The below response letter is in relation to the comments made by the London Borough of Hillingdon. Please review this letter alongside the latest revision of all reports, plans, calculations, and documents (C3783-R1-REV-B).

Application Reference: 3638/APP/2026/1538

Location: *Former Regal Cinema, 233 High Street, Uxbridge, UB8 1LD*

Proposal: Change of use of existing nightclub (Sui Generis) to a banqueting suite (Sui Generis) and development of a hotel (Use Class C1) including the change of use of existing gymnasium (Use Class E) and associated landscaping, car, and cycle spaces (Part retrospective).

ATTENUATION TANK - PLAN VIEW

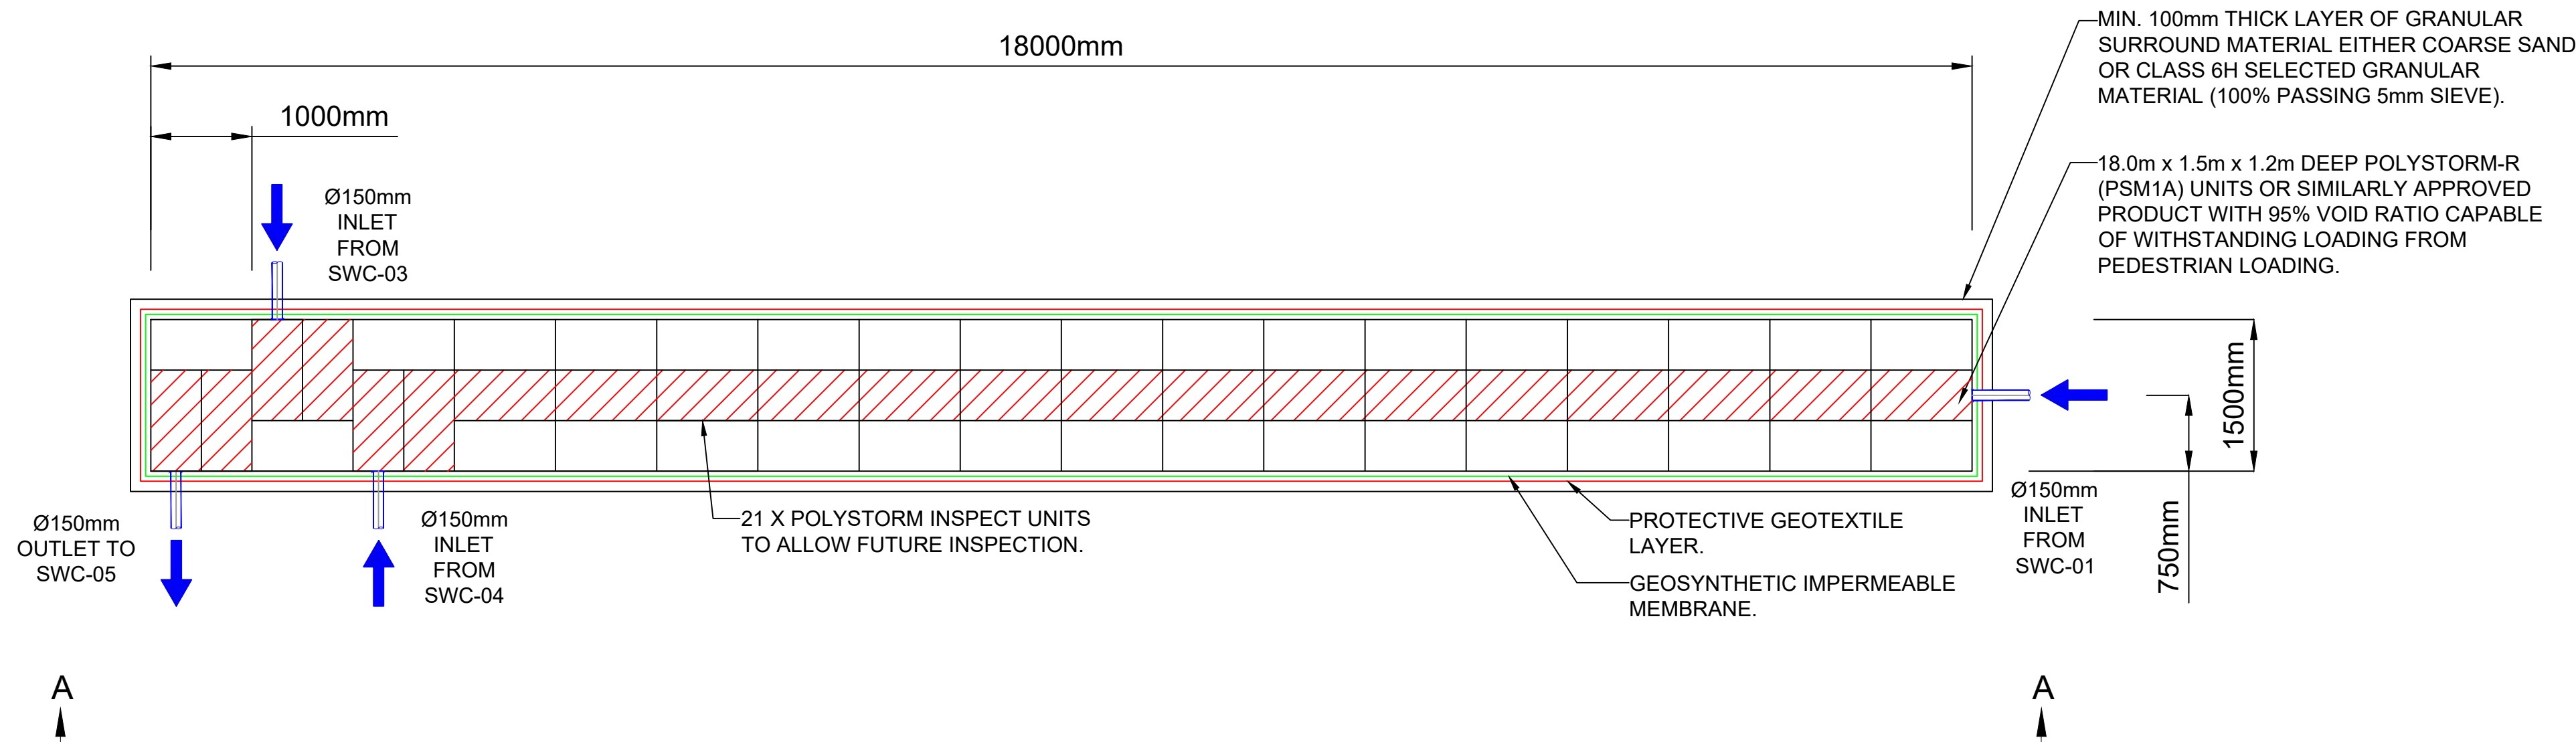
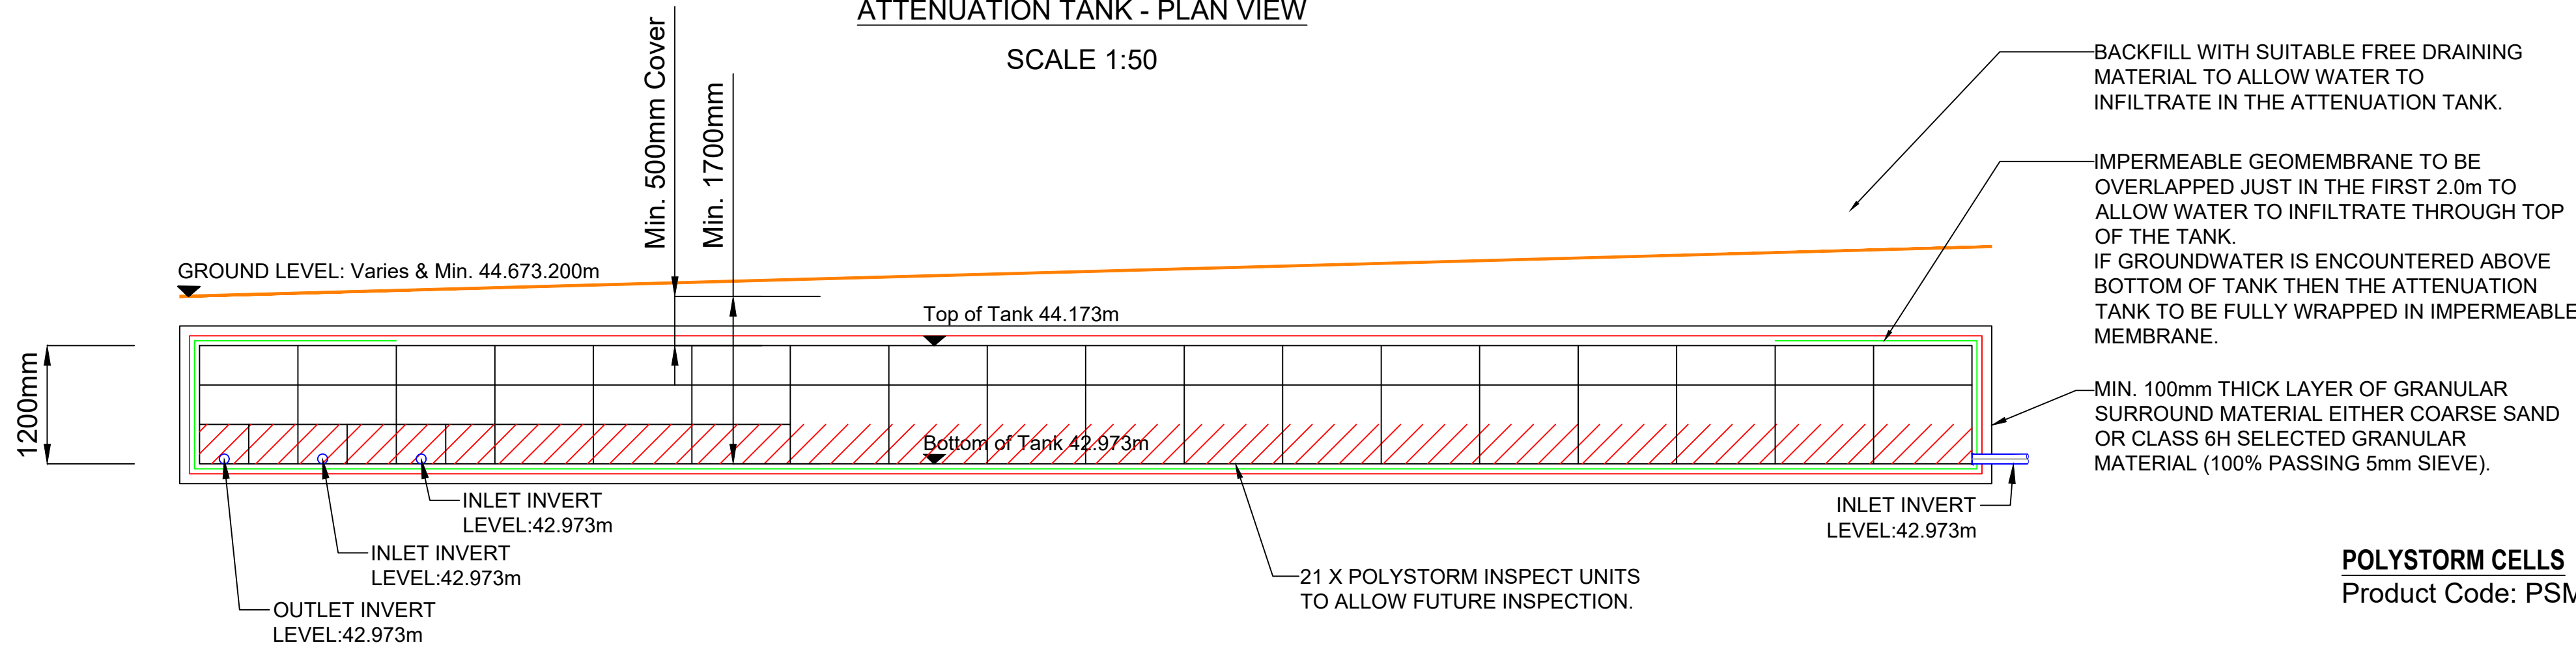
- The attenuation volumes stated in the InfoDrainage calculations do not align with those reported in the London Sustainable Drainage Proforma and SuDS Layout Plan. The applicant should confirm the storage volumes and update the relevant drainage documents;

We can confirm that the attenuation volumes stated within the London Sustainable Drainage Proforma, SuDS Layout Plan, and FRA & SuDS Report are correct with minimum required net storage volume of 54.1m³. The hydraulic modelling sheets, extracted from InfoDrainage, automatically include the storage volume from an access chamber to the cellular storage devices – hence the slight discrepancy in storage volumes.

Blue Roof Type : Cellular Storage	
Dimensions	
Exceedance Level (m)	56.951
Depth (m)	0.100
Base Level (m)	56.716
Number of Crates Long	194
Number of Crates Wide	3
Number of Crates High	1
Porosity (%)	95
Crate Length (m)	0.6
Crate Width (m)	0.6
Crate Height (m)	0.1
Total Volume (m³)	20.039

Cellular Storage Type : Cellular Storage	
Dimensions	
Exceedance Level (m)	42.729
Depth (m)	1.200
Base Level (m)	41.029
Number of Crates Long	20
Number of Crates Wide	3
Number of Crates High	3
Porosity (%)	95
Crate Length (m)	1
Crate Width (m)	0.5
Crate Height (m)	0.4
Total Volume (m³)	34.700
